Rezoning Transportation Analysis

Petition Number: 2020-145

General Location Identifier: Tax ID: 22313218

Date	Description
11-30-20	First Review (LJ)
12-28-20	Second Review (LJ)

SHEET TITLE
REZONING SECTIONS

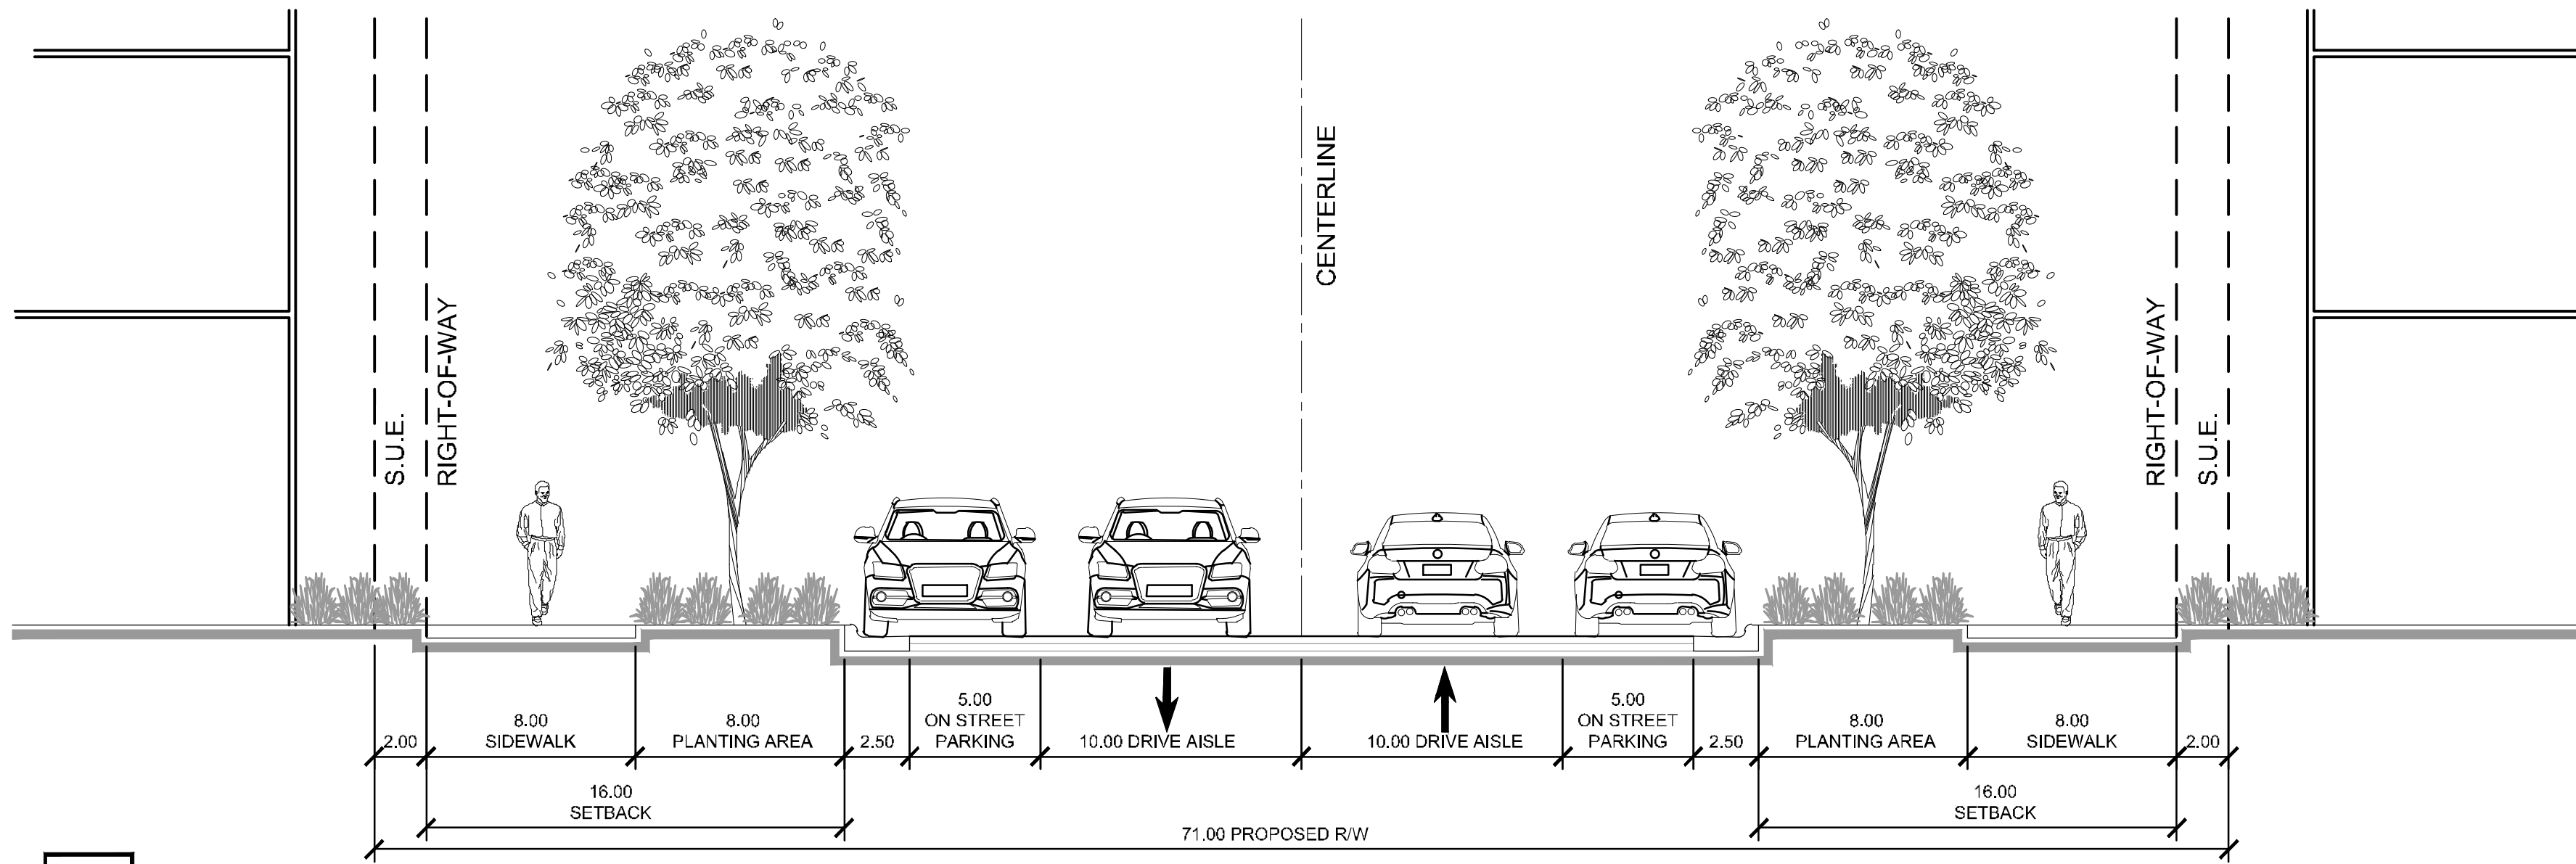
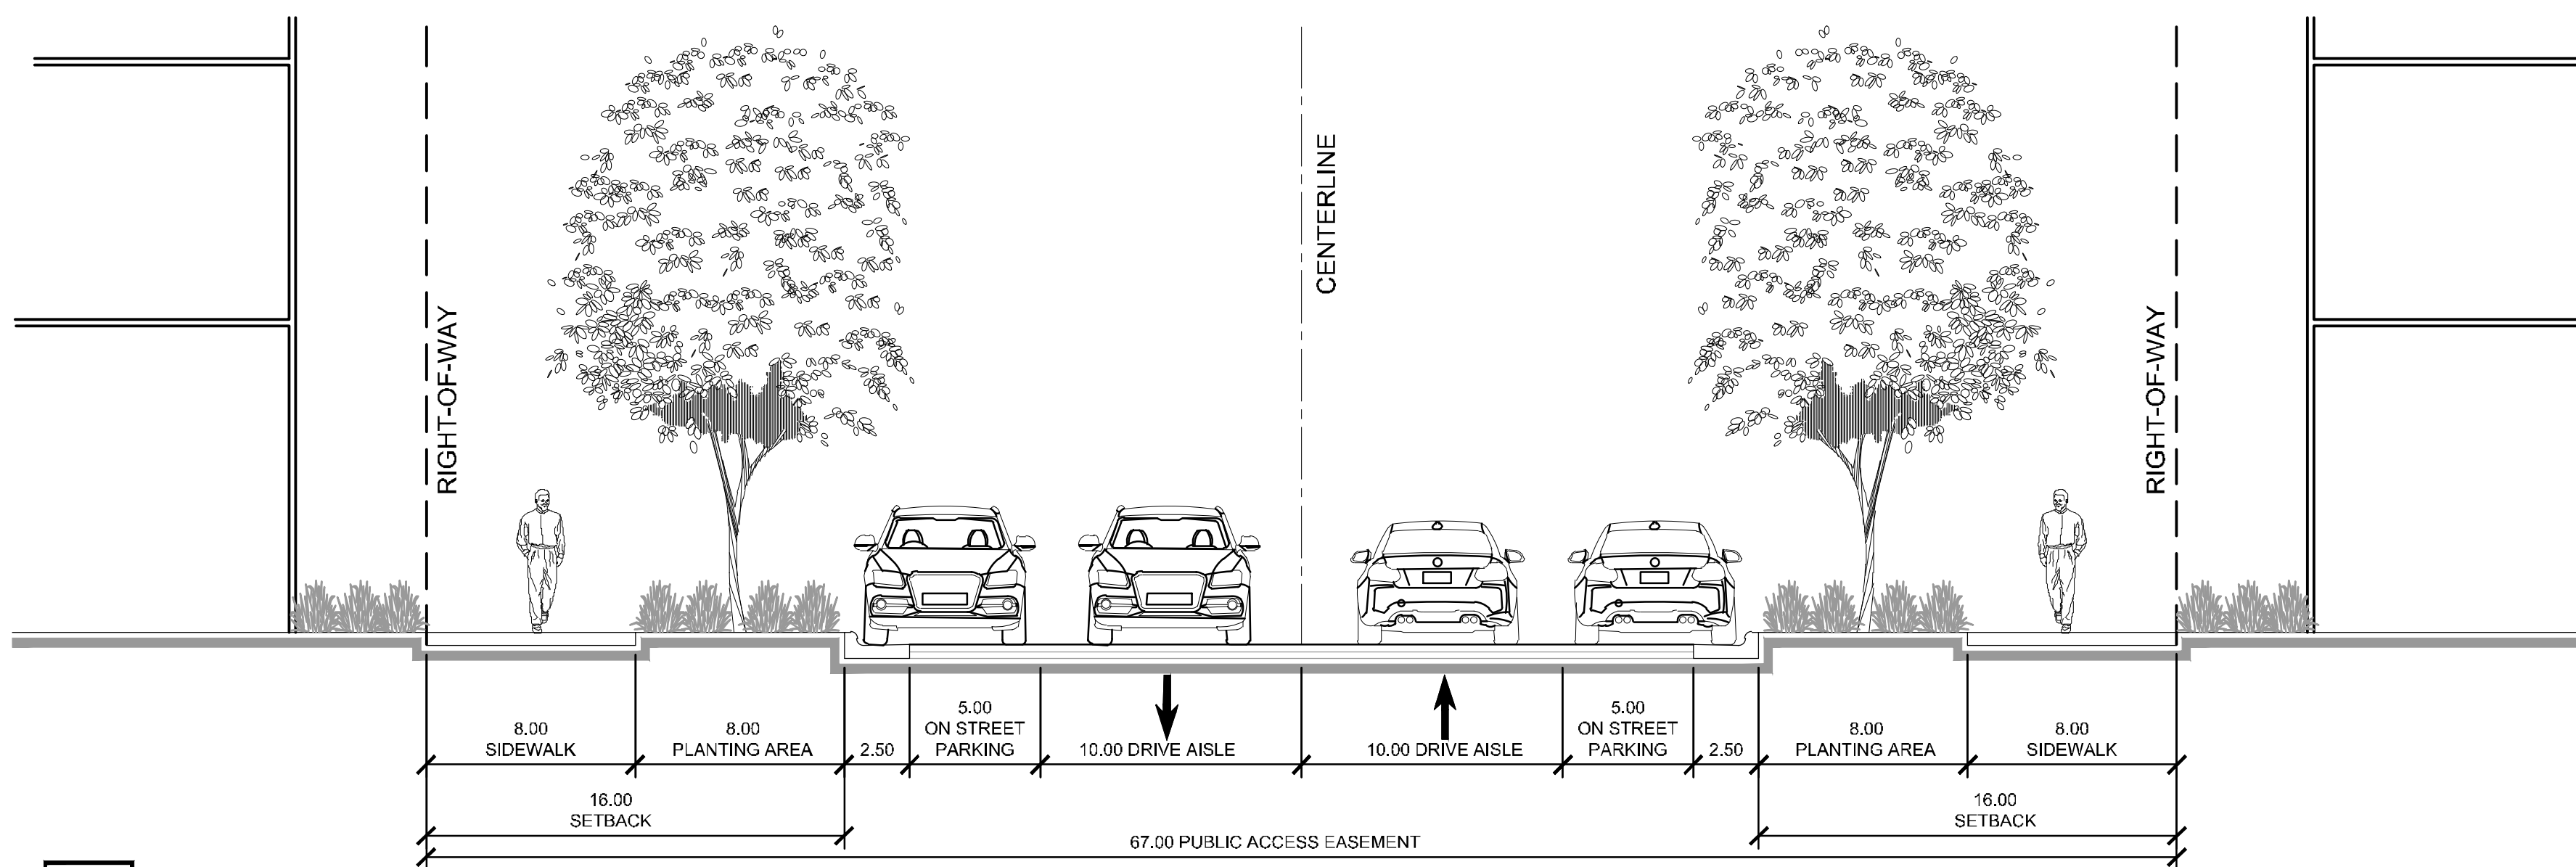
- ~~3. **Revise site plan and conditional note(s) to commit to dedicating 71' right-of-way for the Public Streets 'A' and 'B' per Chapter 20 and CLDSM, U-03A.19. The site plan shall label and dimension the right-of-way from road centerline.**~~

~~Revise site plans and conditional notes to commit to constructing an 8 foot planting strip, and 8 foot sidewalk along Public Roads 'A', 'B', and 'C' per Chapter 20, as the proposed dwelling units exceed 12 per acre. The wider sidewalk also meets the Charlotte WALKS Policy. The site plan shall label and dimension both items from the back of curb and gutter to the road centerline.~~

~~Reference (CLDSM standard detail U-03A) for street typical.~~

TECHNICAL DATA SHEET

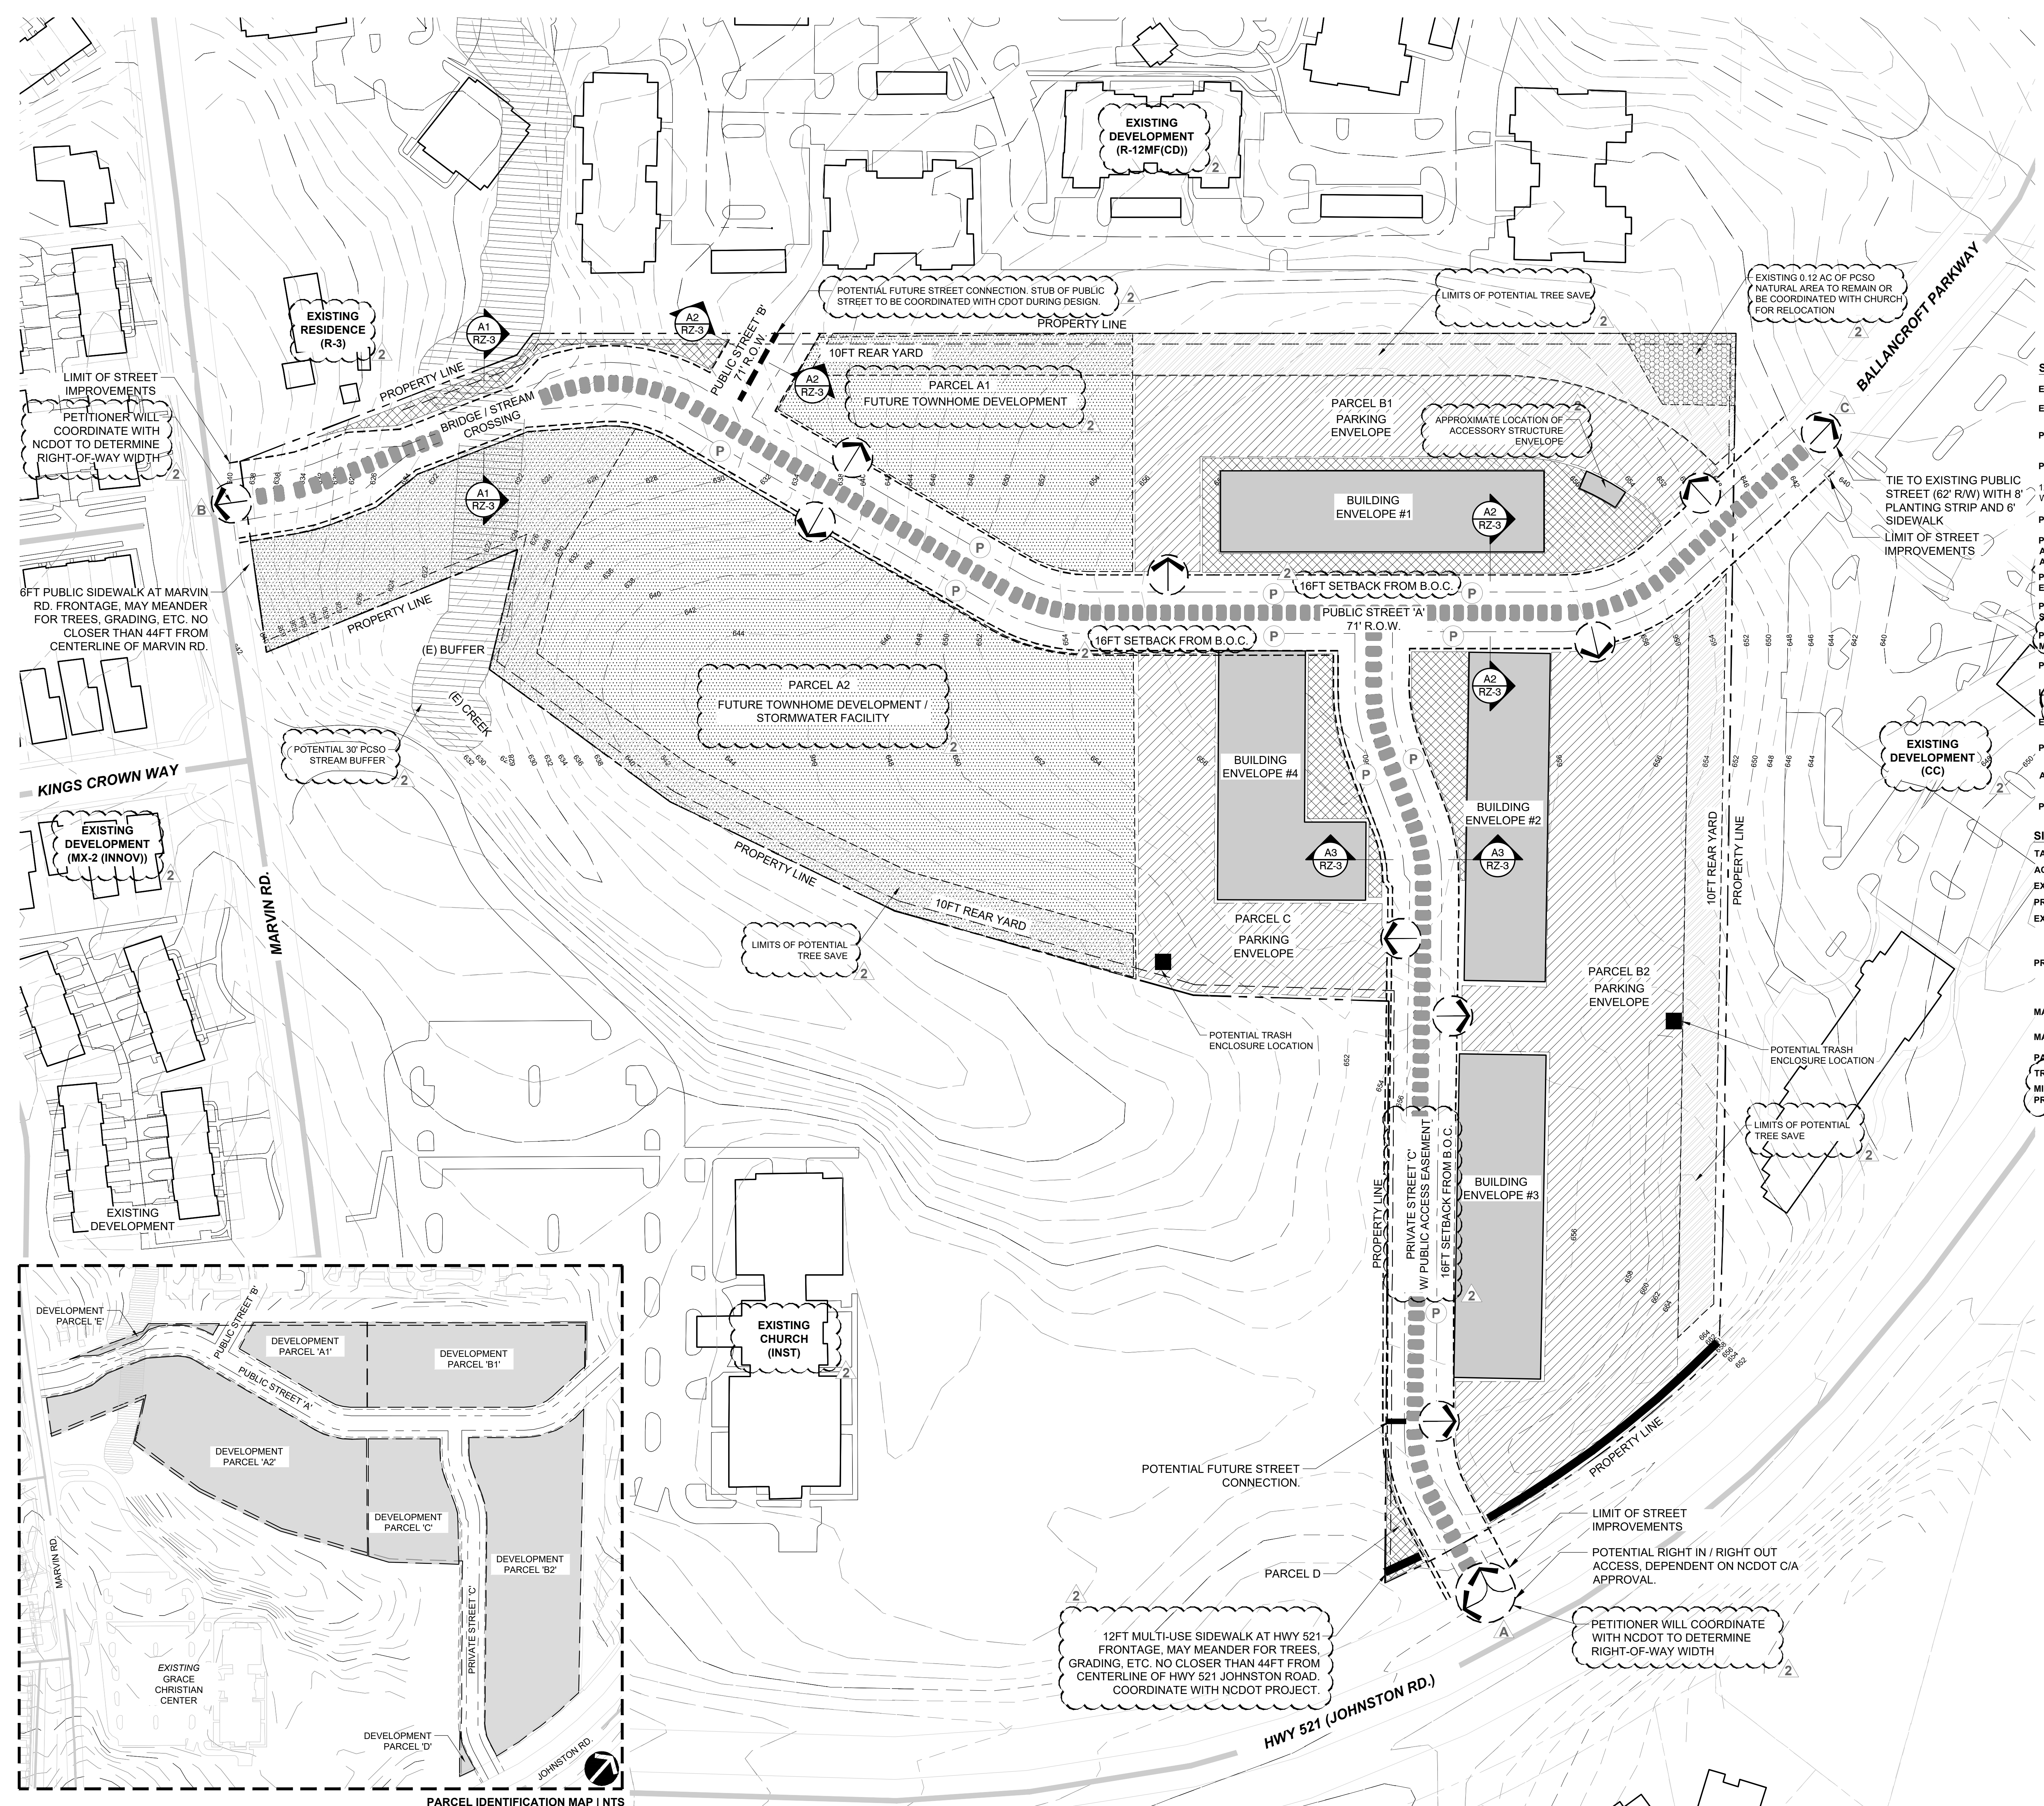
8. Add a site plan note specifying that all transportation improvements will be approved and constructed before the site's first building certificate of occupancy is issued is needed. The petitioner may phase transportation improvements if said improvements and phasing are explicitly described in site plan notes.
